2.2 Consented Scheme Comparison Proposed Scheme - Second Floor

Proposed Roof Plan Part 11

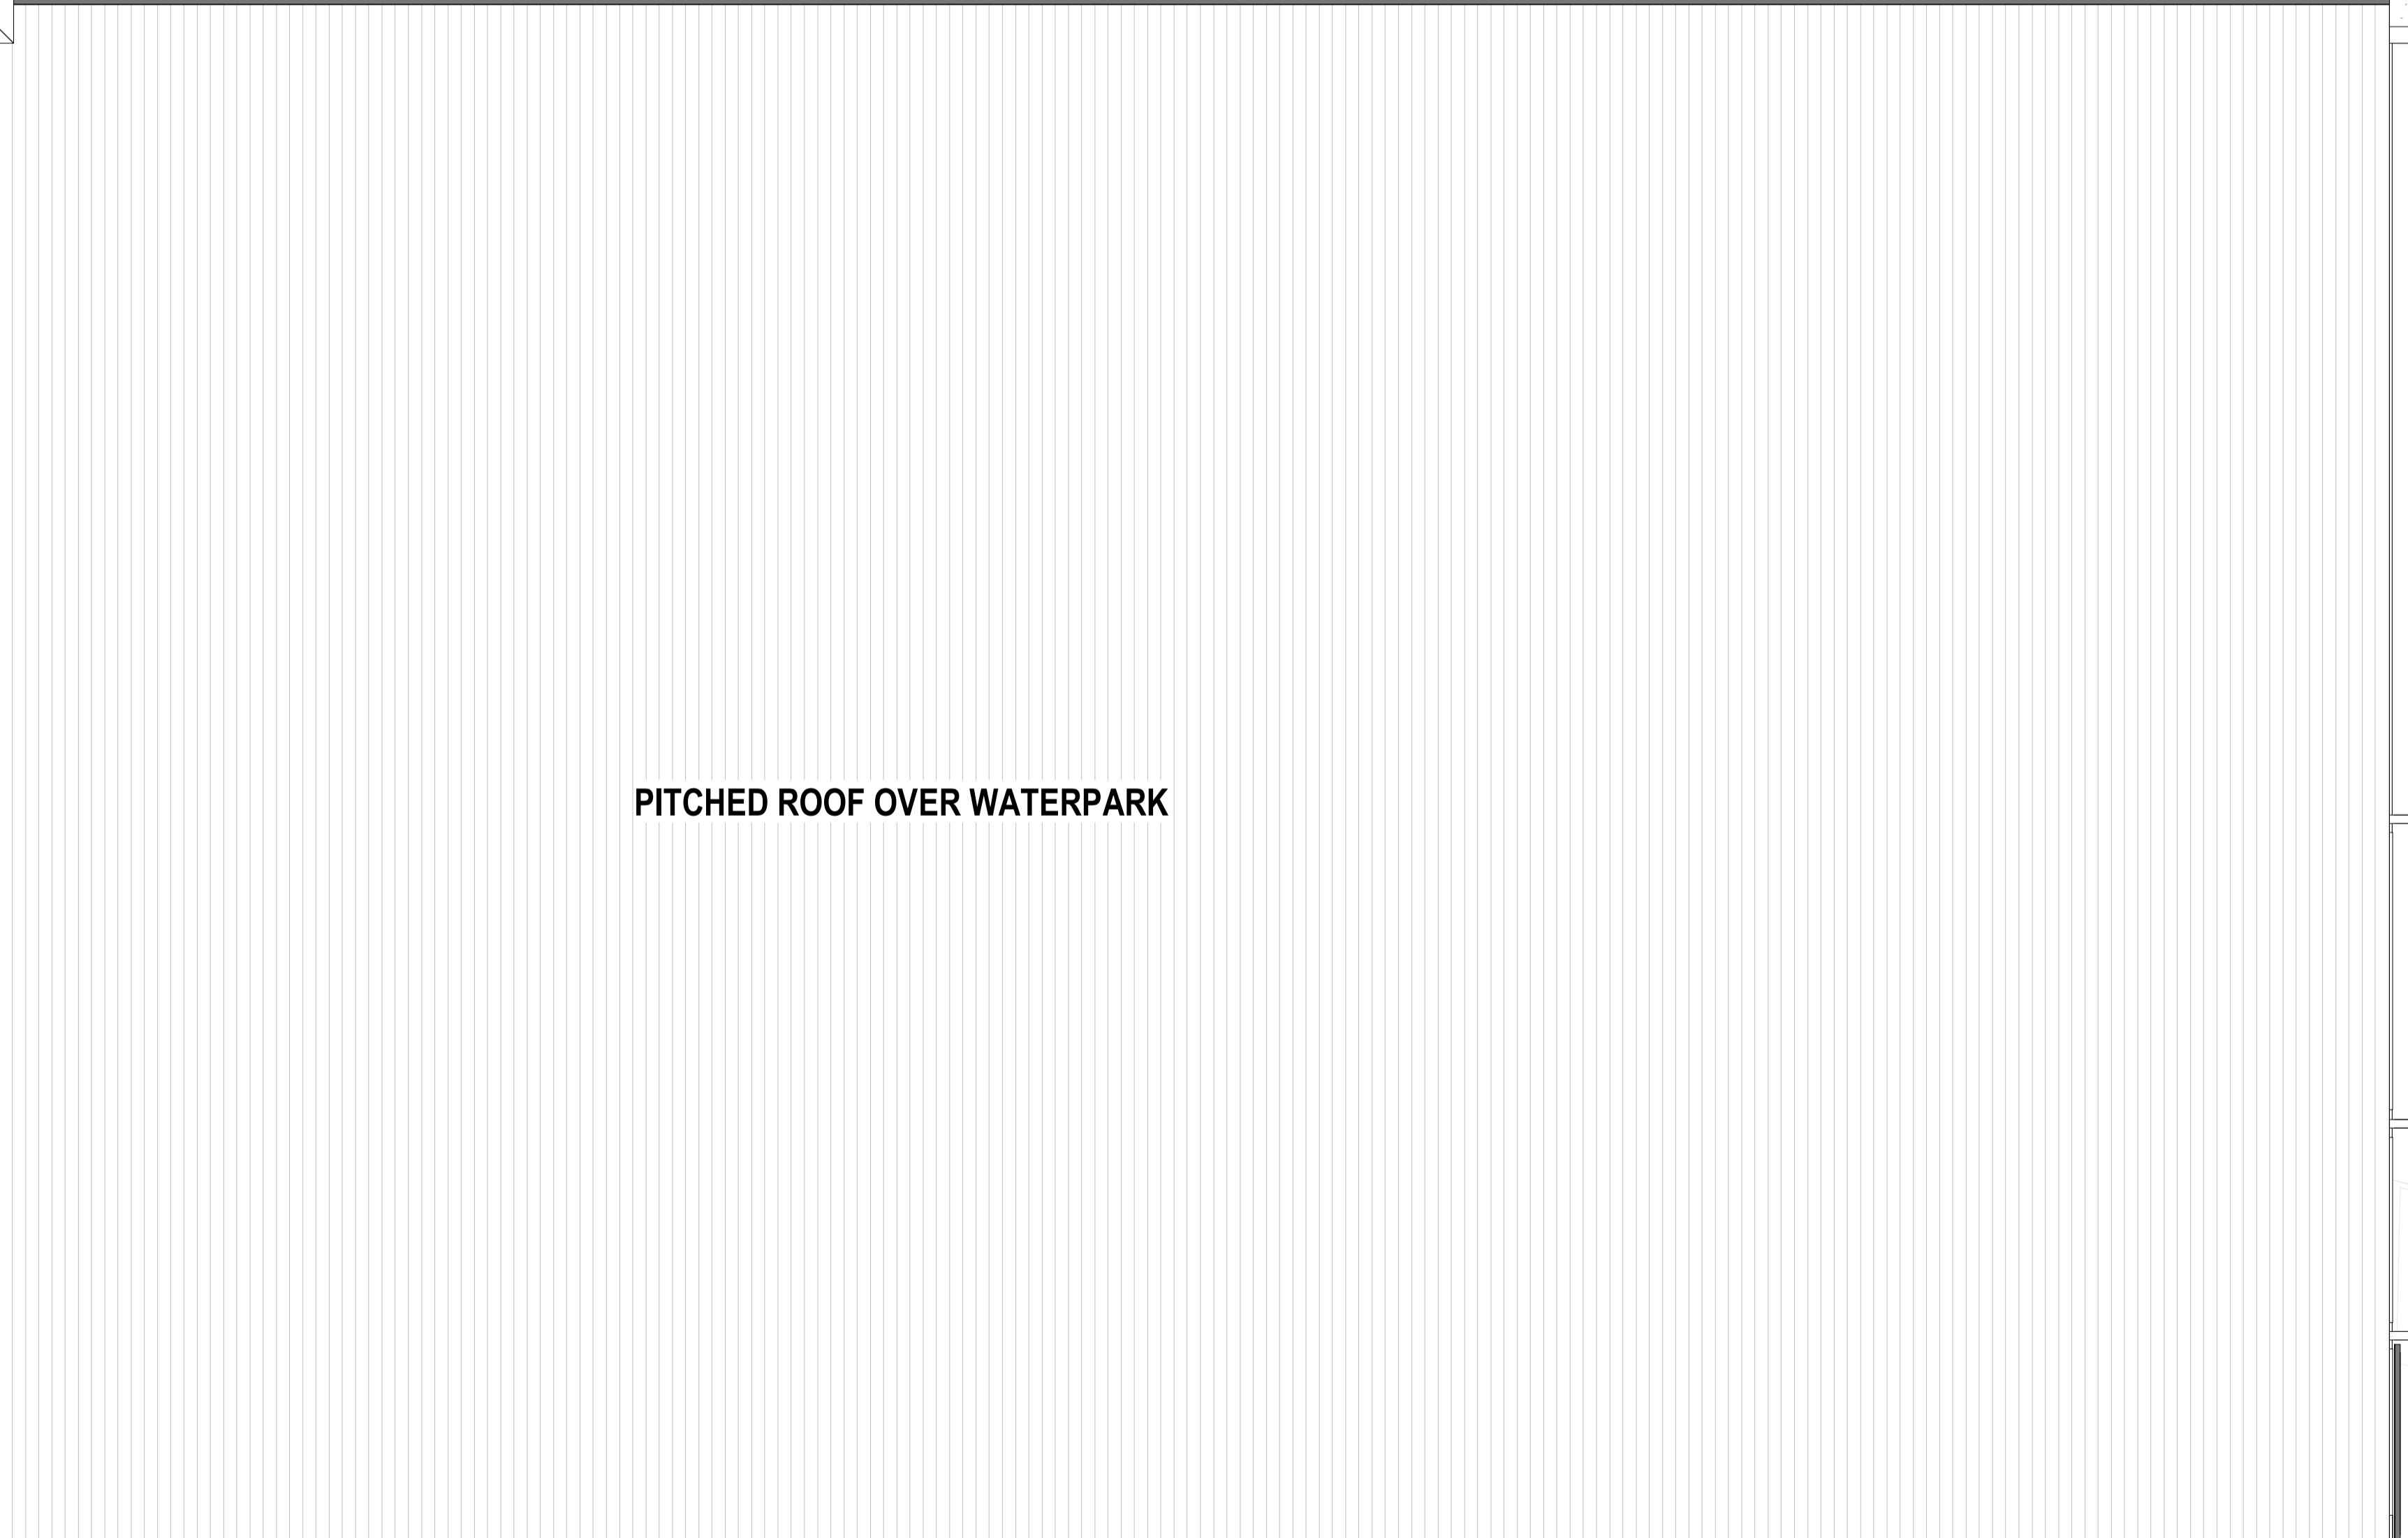
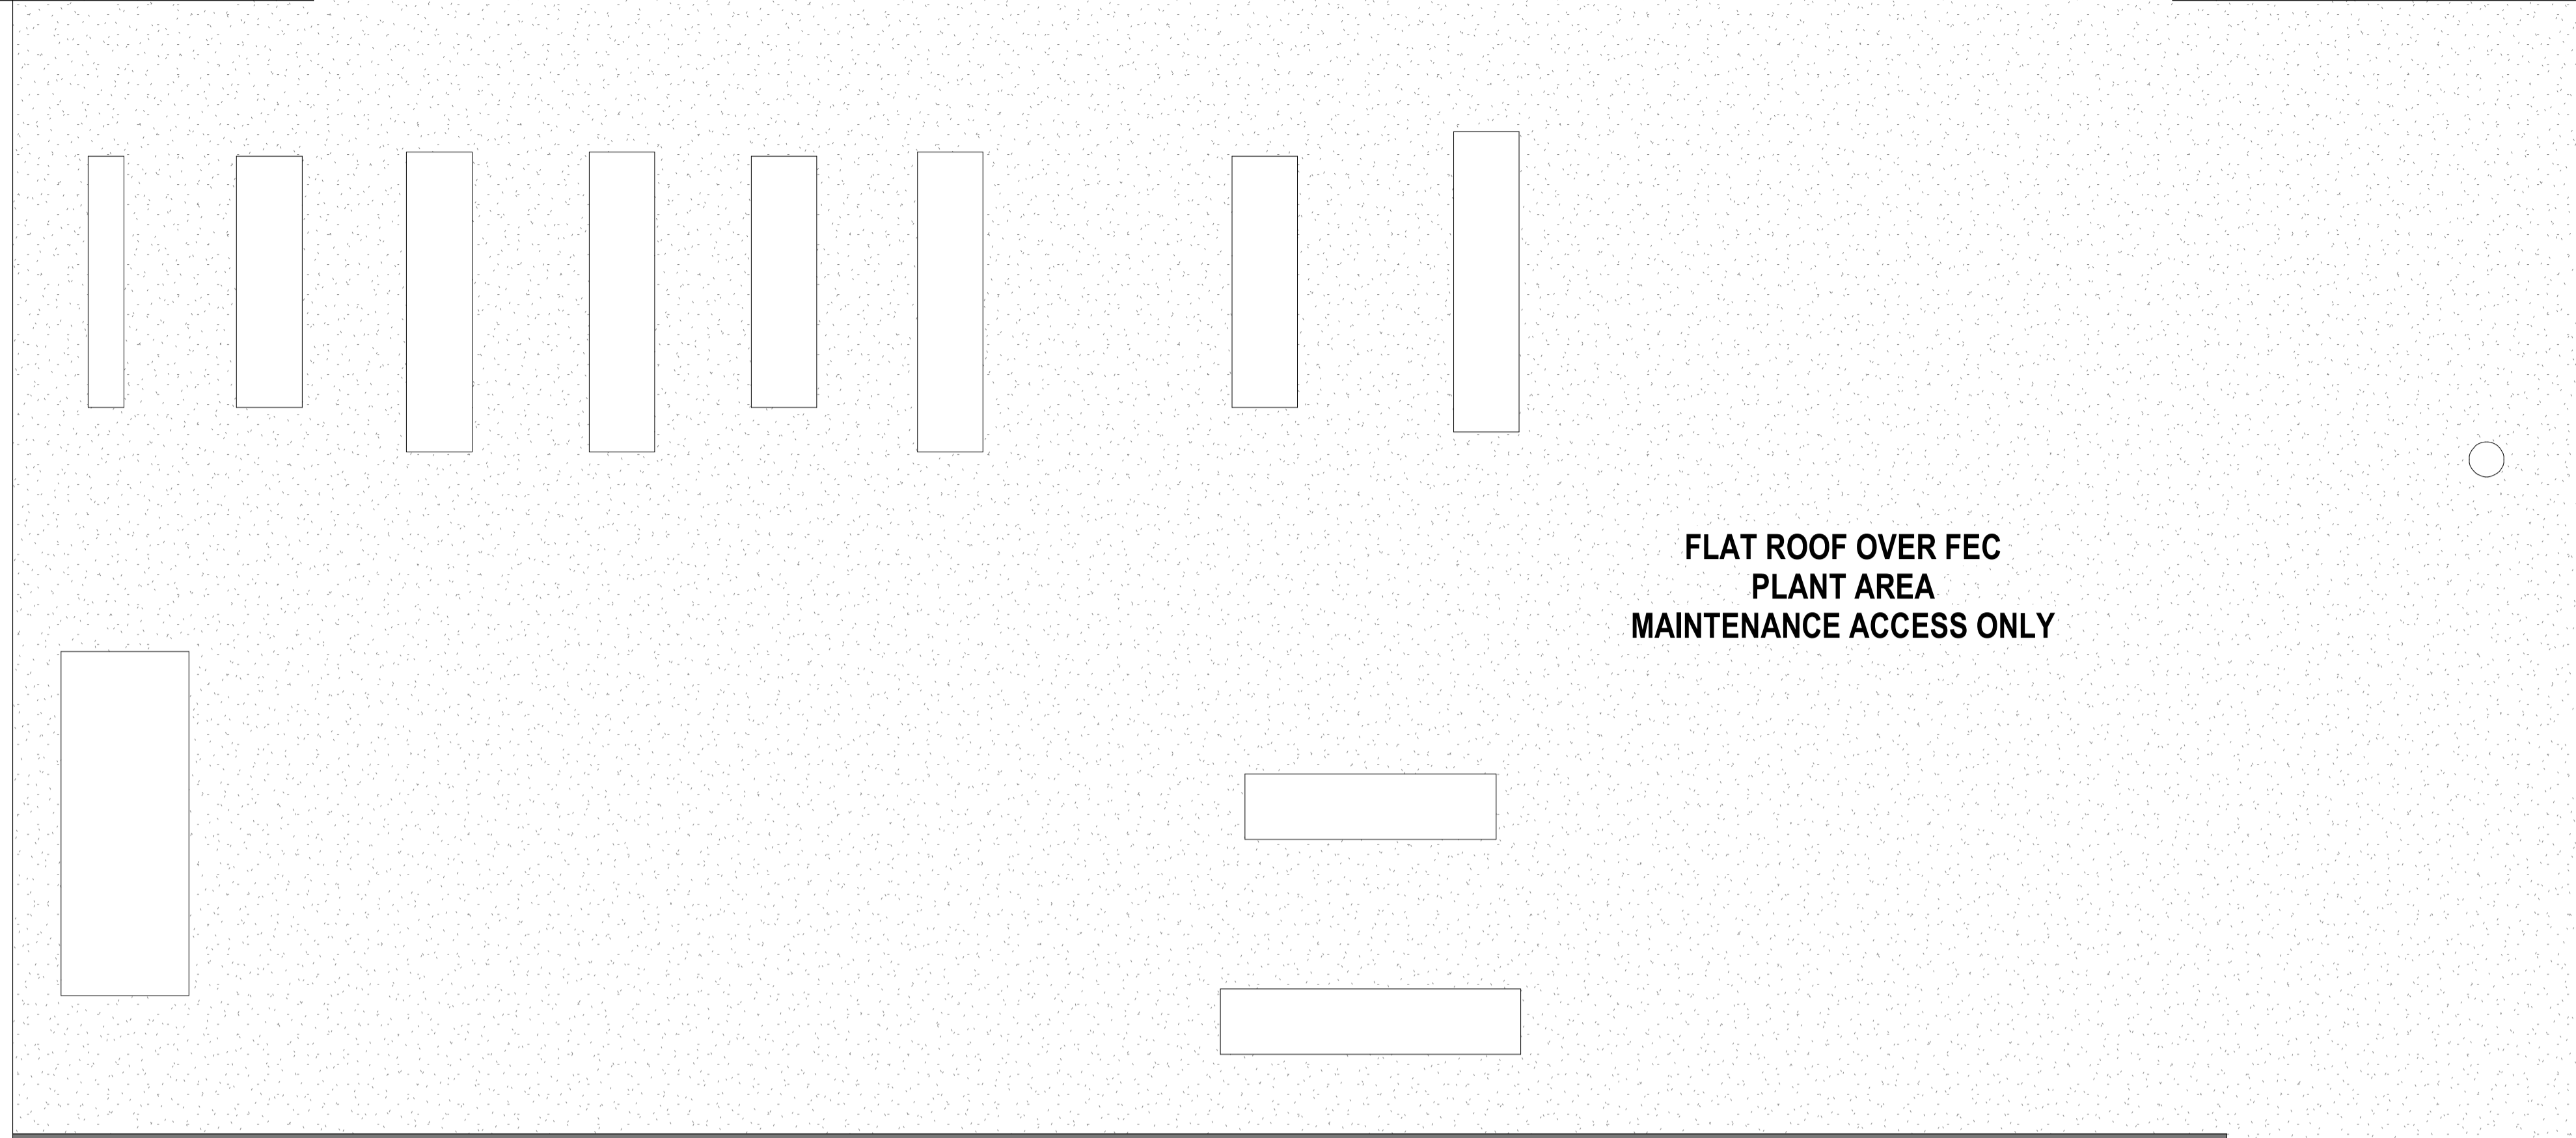
2.2 Consented Scheme Comparison Proposed Scheme - Roof Plan

- ① Reduction in the overall size of the FEC resulting in a shift of the guestroom u-shaped tower southwards by approx. 3.6m.
- ② Water slide design updated.
